Written representation by Richard (“Dick”) Jeffcoate – my comments on responses made by the Applicant to Relevant Representations submitted by me to the Planning Inspectorate on 23.11.25

An issue raised in my Relevant Representations and focused upon in my oral submission is designation of The Street, Grittleton as an access to the proposed contractor’s compound on the east side of Grittleton village and as part of the construction route to the “Cable Route Corridor” access point, also on the east side of Grittleton village. In particular, use of The Street for use by Abnormal Indivisible Loads.

APFP Regulation: APFP Regulation: 5(2)(a)  
Application Doc no.: APP /6.2  
Drawing no.: Figure 13-11

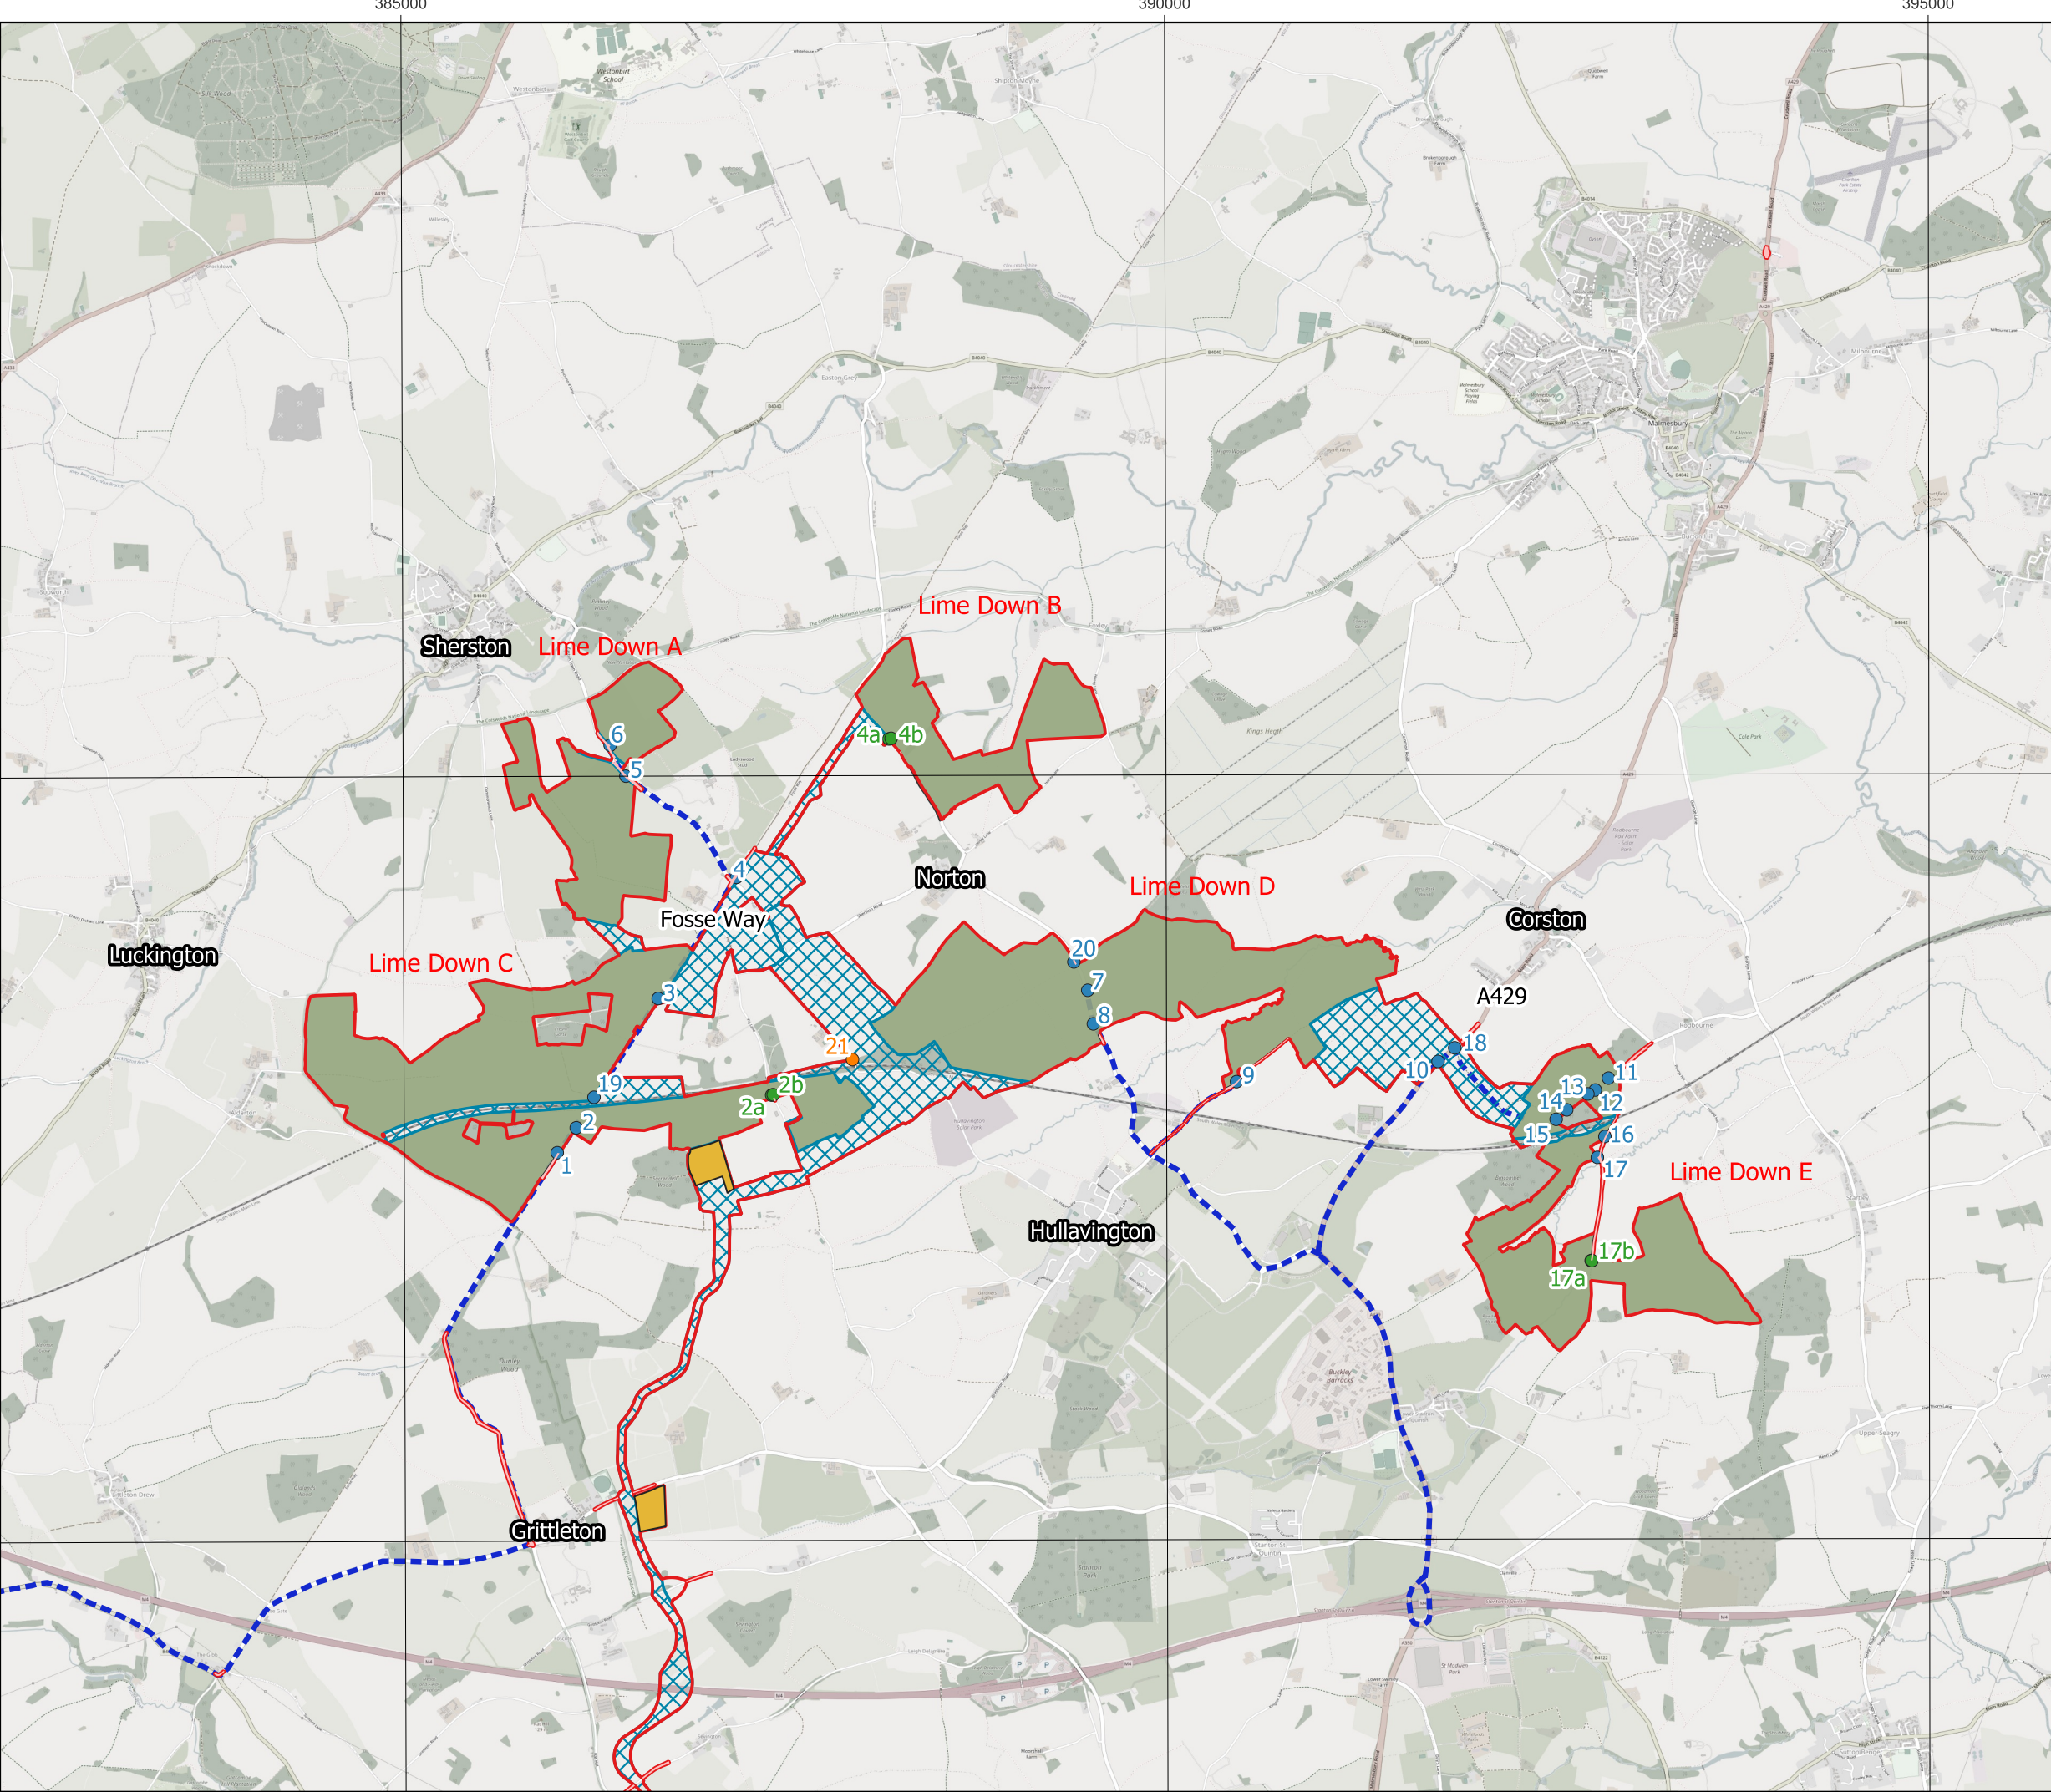
In my opinion, The Street, Grittleton is unsuitable for use by traffic of the type that would be generated by the proposed Lime Down development and I respectfully refer you to my comments on this issue, as set out in my Relevant Representations and my oral submission.

That statement does not appear to me to be correct. I refer to paragraphs 1.2.41 and 1.2.42 of the Applicant’s Environmental Statement Volume 3 APP-233 in which The Street, Grittleton is listed as one of the roads that are to form part of the construction routes to the Cable Route Corridor access points.

2) With further reference to paragraph 1.2.42 of the Applicant’s Environmental Statement Volume 3 APP-233, The Street, Grittleton is described as “a two-way single carriageway road”. Whilst that is technically correct, the Applicant has made no reference to the presence of vehicles lawfully parked on The Street. As mentioned in my Relevant Representations and my oral submission, residents of numerous houses adjacent to or fronting The Street, including mine, have no off-street parking available to them. We all park on The Street. Take into account home delivery grocers’ vans; visitors’ cars; parcel delivery vans; deliveries to the pub; pub visitors; people attending the church; oil tankers delivering heating oil; bin lorries; garden contractors with equipment trailers etc, street parking is integral to village life.

Vehicles parked lawfully on The Street reduce the available width of the roadway for use by other vehicles. In effect, this makes lengthy sections of The Street single track. Assumptions made by the Applicant as regards highway width and suitability of The Street for traffic associated with the proposed project should, I believe, be rigorously questioned. As I understand it, an “abnormal load” such as a cable delivery would have a width of at least three metres and a rigid length of at least 18.65 metres.

I urge the Examining Authority to form the view that designation of The Street, Grittleton as an access to the proposed contractor's compound on the east side of Grittleton village and as part of the construction route to the "Cable Route Corridor" access point, also on the east side of Grittleton village, in particular, use of The Street by Abnormal Indivisible Loads, is not appropriate, even with mitigation measures mentioned by the Applicant in place.
